KITTITAS COUNTY

MEMORANDUM

TO: All Staff
FROM: Public Works Plan Review Team
DATE: March 30, 2026 – Update June 18, 2026
SUBJECT: BL-26-00002 Fowler Creek Trails

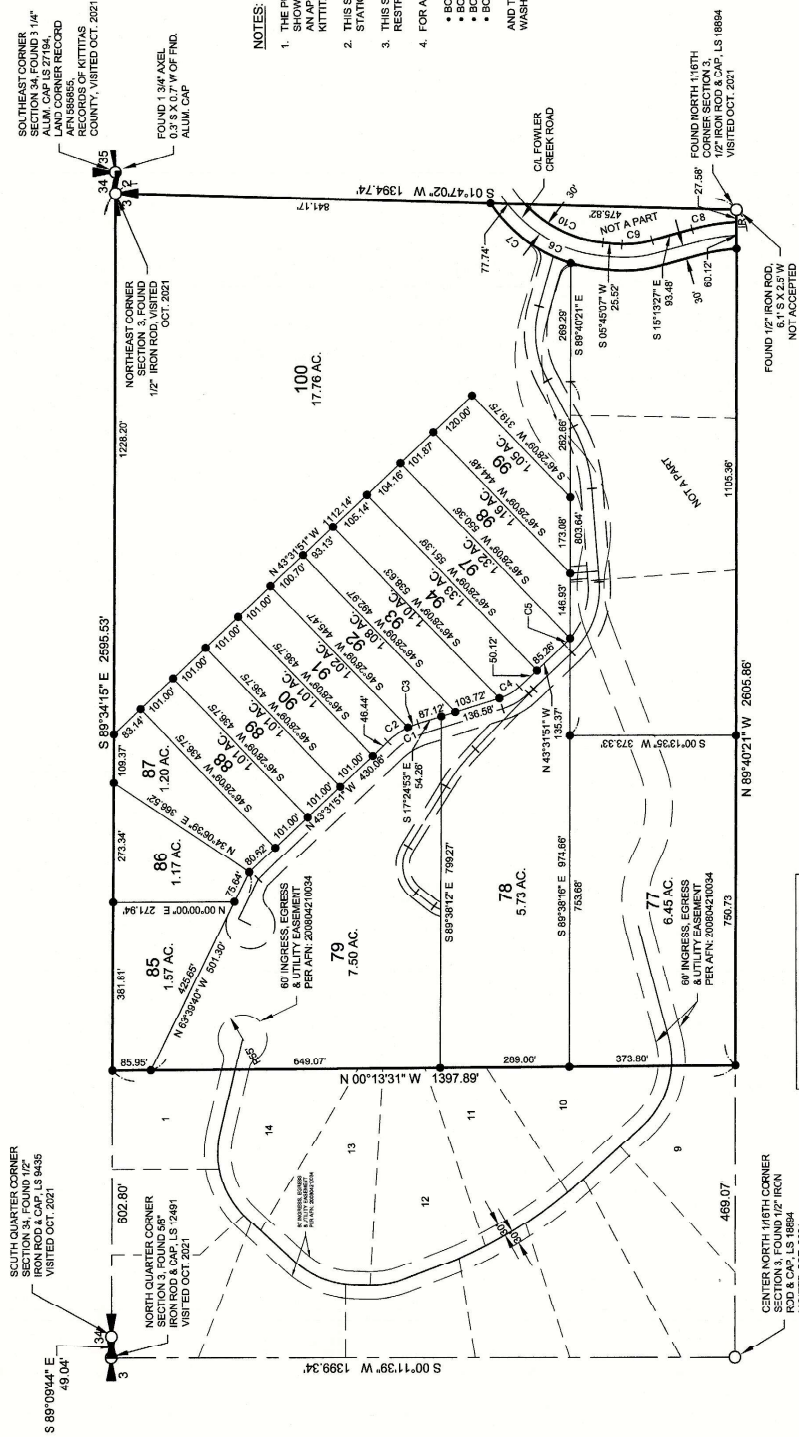
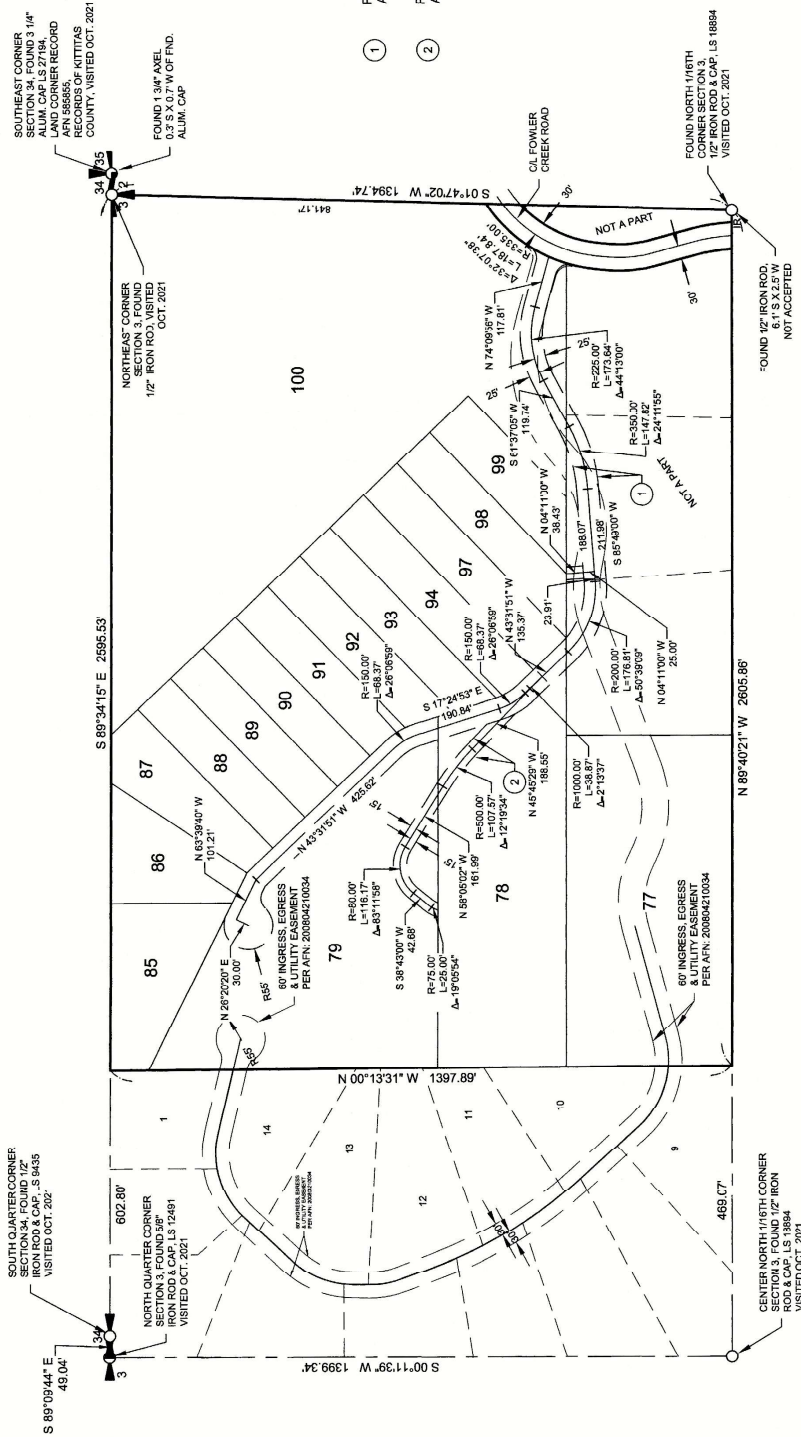
ENGINEERING	Except as exempted in KCC 14.05.060, no grading or filling upon a site involving more than one hundred (100) cubic yards shall be performed without a grading permit from the County Engineer or Public Works designee (KCC 14.05.050). An application for grading in excess of five hundred (500) cubic yards shall be accompanied by an engineered grading plan (KCC 14.05.080). (CBP)
SURVEY	As the application does not contain a survey map, comments are herein reserved until final submittal. (JT) UPDATE 06/16/2026 1. Lot closures were not provided. Lot closures will need to be reviewed prior to final approval. 2. Basis of Bearing is not shown or noted. 3. Existing boundary lines are not shown. Sheets 1 & 2 4. Existing lot numbers shown on adjacent parcels should include reference to the creating documents.

5. Text size on easement note located West of subject parcel does not meet minimum size. 6. Outside perimeter of Subject Parcel should be a bold solid line. Bold Solid line appears to include areas outside subject parcel. 7. Please include ownership and surfacing for Fowler Creek Road. 8. The SE corner of Sec 34. Need to include a distance/bearing tie. 9. Minor typo on Found Axle near SE Cor Sec 35. 10. Distance of 803.64 near South line of Lot 99, needs to include bearing. 11. Curve 21 has a minor discrepancy between curve table and legal description. Sheet 5 12. Legal description of Lot 100 shows a bearing for the central angle. (JT)
TRANSPORTATION CONCURRENCY	No comments. (KH)
FLOOD	No comments. (SC)
WATER MITIGATION/ METERING	No comments. (SC)
AIRPORT	No Comment.
